30 October 2013

**Re: Proposed modifications for additional Viewing Room to Warehouse 1, Bungaribee Industrial Estate, Huntingwood, approval MP10-0140.**

Enclosed are copies of the BCA Assessments for both the Metcash Base Building and the Project Mustang Extension works applicable to Warehouse 1 at the Metcash facility, Bungaribee Industrial Estate, Huntingwood that is the subject of the proposed modifications.

GROUND PLAN
SCALE 1:100

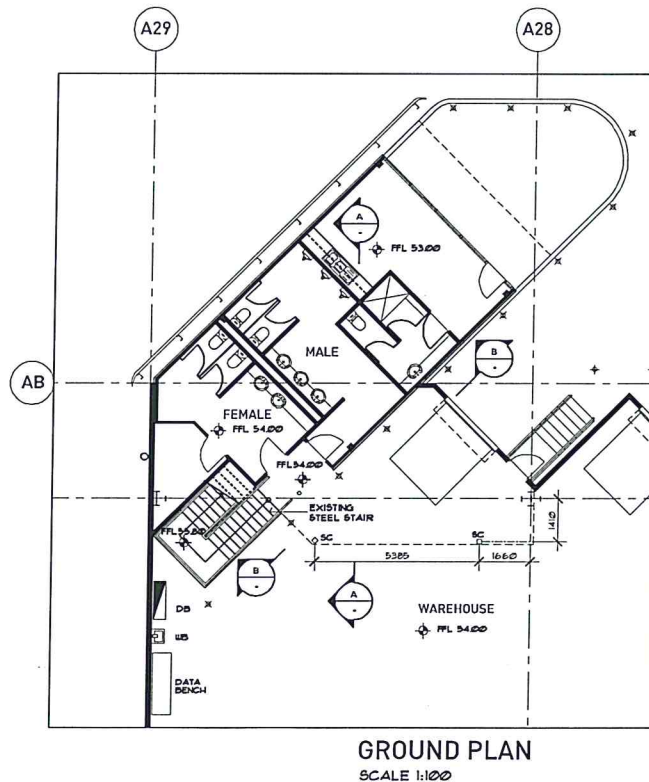
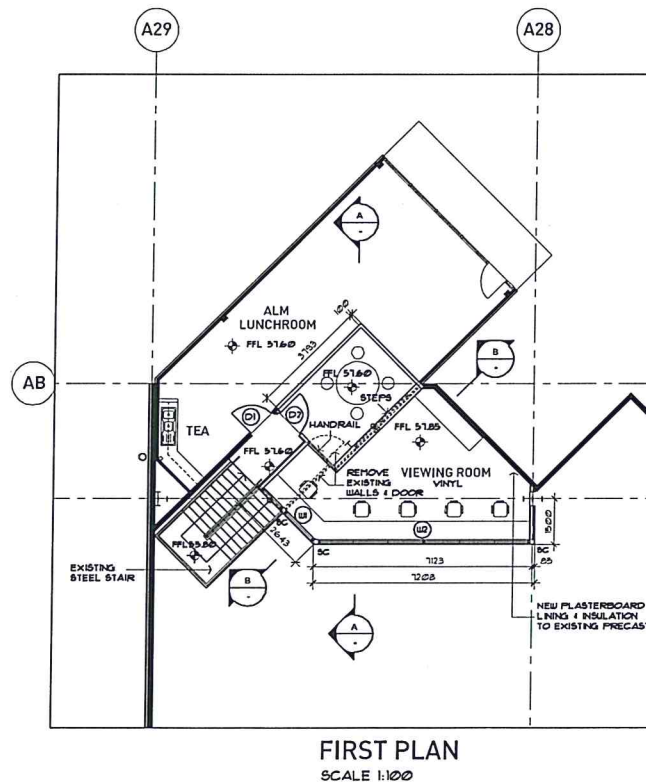
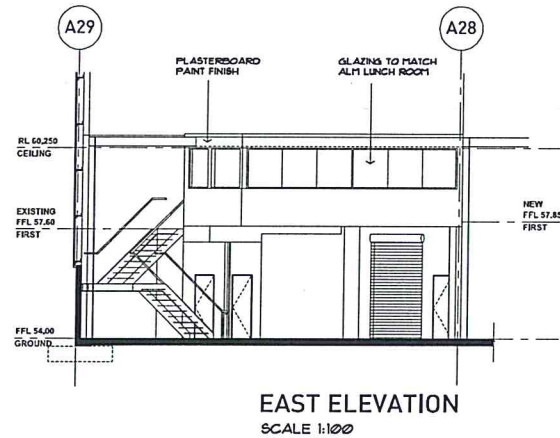
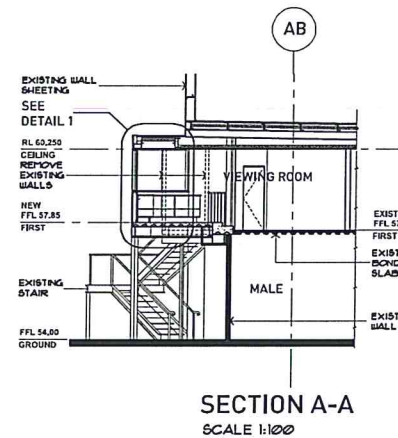
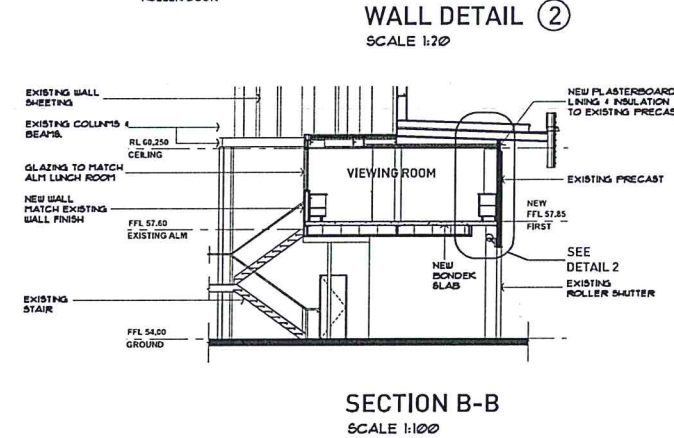
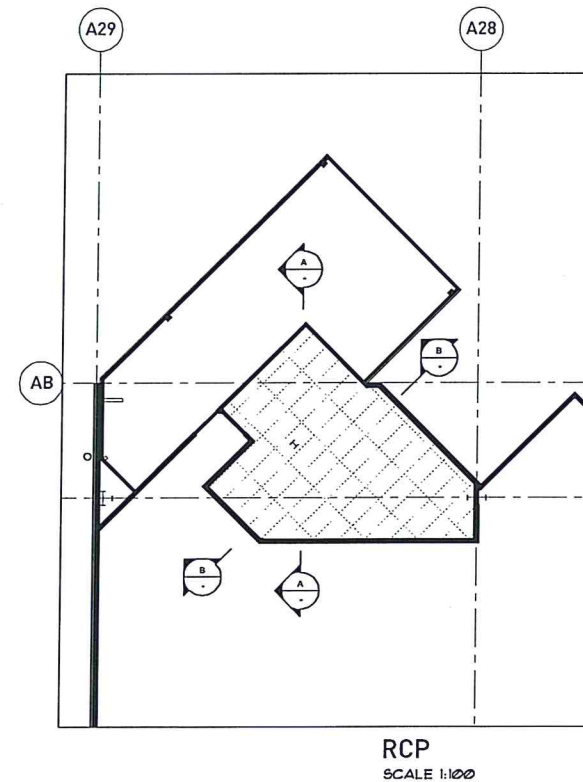
Floor, wall and ceiling linings are required to comply with the requirements under specification C1.10. Certification of design will be required at CC Application stage and test certificates of the proposed linings will be required to be submitted prior to issue of the Occupation Certificate.

The proposed viewing room will not result in any non-compliance with regards to egress distances. However, comment is required from the Base Building Fire Engineer (Rawfire) confirming proposed modifications do not impact upon the recommendations of the Fire Engineering report for both the Base Building and Project Mustang.

The proposed viewing room does not impact upon the distance between alternative exits. However, comment is required from the Base Building Fire Engineer (Rawfire) confirming proposed modifications do not impact upon the recommendations of the Fire Engineering report for both the Base Building and Project Mustang.

Where the areas associated with the new addition would be deemed to be inappropriate for people with a disability due to the particular purpose for which the area is used or would pose a health or safety risk to people with a disability, access would not be required from the main entry to the new addition. Details are to be provided by Metcash to the Access Consultant for review and comment. A report from an Access Consultant in this regard is required at CC Application stage.

The new viewing room is required to be provided with Hydrant coverage complying with AS 2419.1 – 2005. Details and design certification is to be provided by the Hydraulic Consultant for review and comment as part of the Construction Certificate assessment.

The buildings are required to be served by Fire Hose Reels complying with this clause and AS 2441 – 2005. Details and design certification is to be provided by the Hydraulic Consultant for review and comment as part of the Construction Certificate assessment.

Exit Signs and Emergency Lighting are required to be provided in accordance with AS 2293.1 – 2005 throughout the new portion of the building.

The viewing room is required to satisfy the Energy Efficiency requirements under this section. We understand that the proposed addition will not be a Conditioned Space and therefore the requirements Parts J1 (Building Fabric), J2 (External Glazing), J3 (Building Sealing), and J5 (Air-conditioning & Ventilation Systems) will not apply.
